**Re: 31 Fore Street - Average Grade**

Jeanie Bourke  
Code Enforcement Officer/Plan Reviewer

3-7-16 AVERAGE GRADE CALCULATIONS SUMMARY

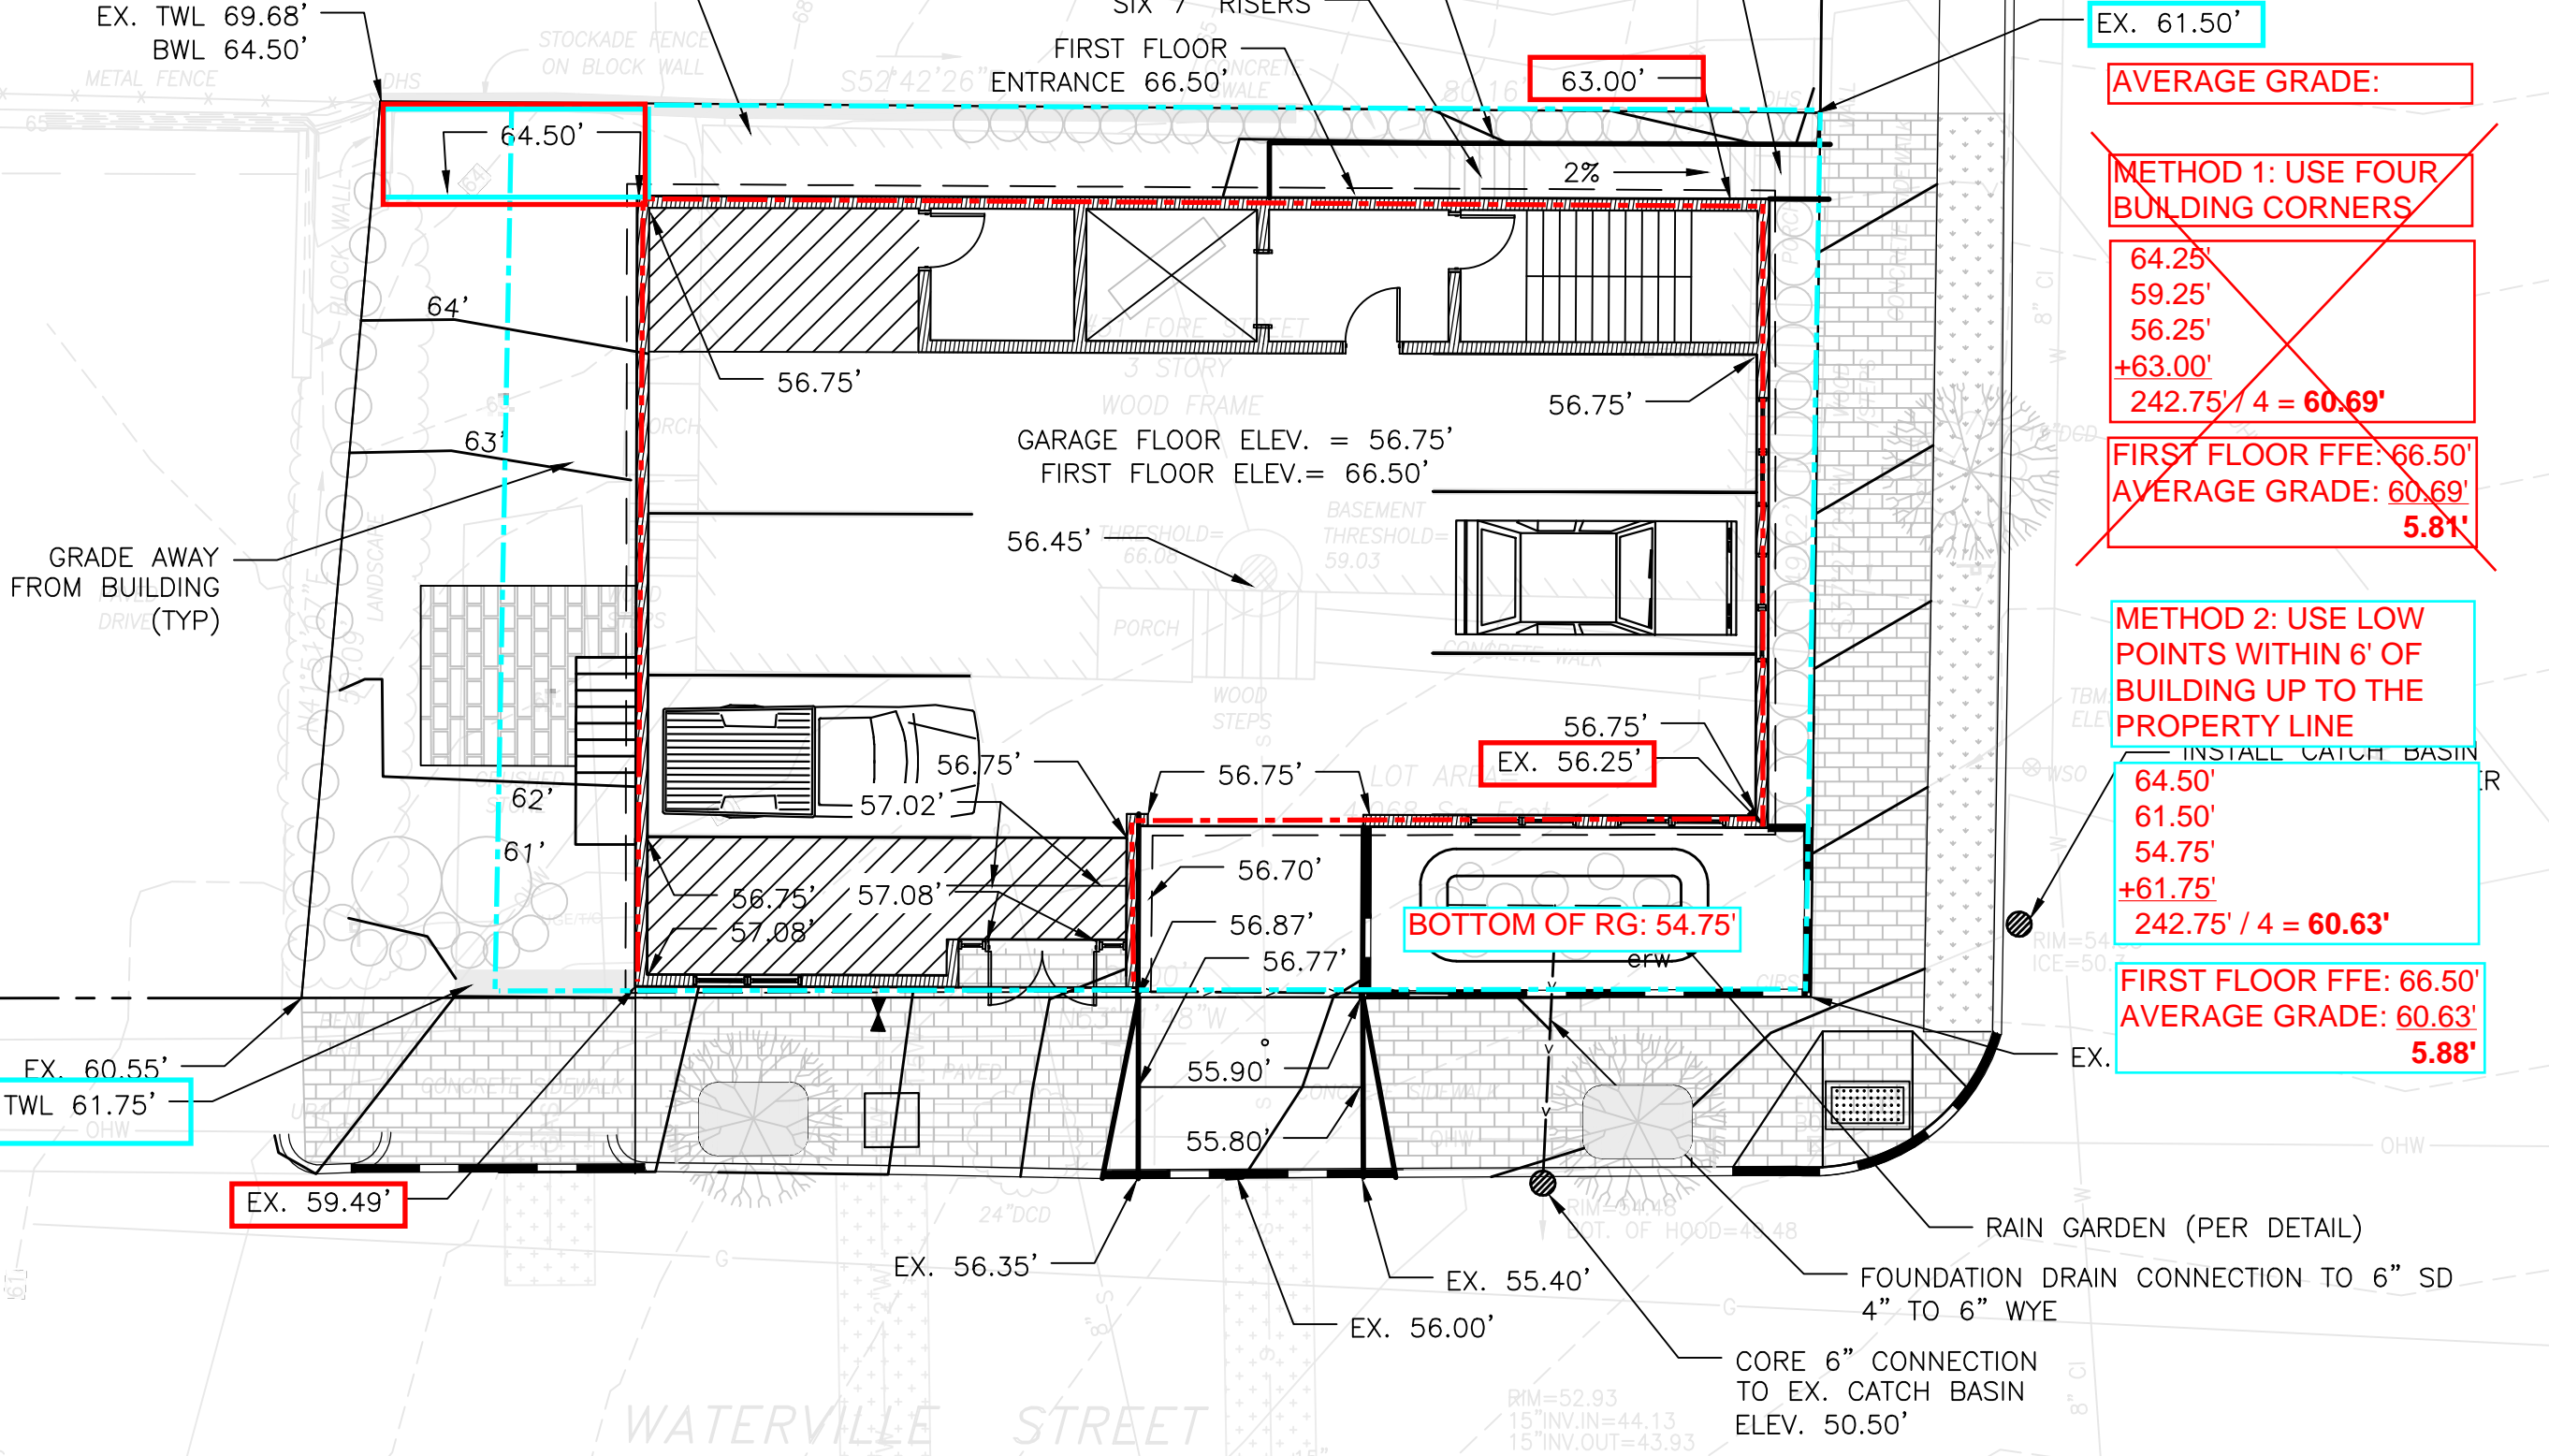
Thank you for submitting the updated grade changes for review. Based on the new calculations that modify the grading around the building, either to the established property line or 6' perimeter distance, it appears the first level will not be considered a story above grade plane. As I understand, the building will be 3 stories above this level and could then be designed to comply with all of the requirements of a single exit building for an R-2 residential apartment occupancy.

For the prior submissions the design team's average grade determination was used at the exterior of the building, we have now updated the calculations using the more conservative method as outlined below. When applied the average exceeded 6ft. As such we have revised the Grading Plans to once again establish the grade plane to within the maximum height of 6 ft. This was accomplished by some minor grade change (3") to the rain garden, rear property line corner and the addition of a 30" landscape wall at the uphill corner on Waterville. Overall the grade changes help blend the site into the existing grades. Please refer to the updated plan with calculations.
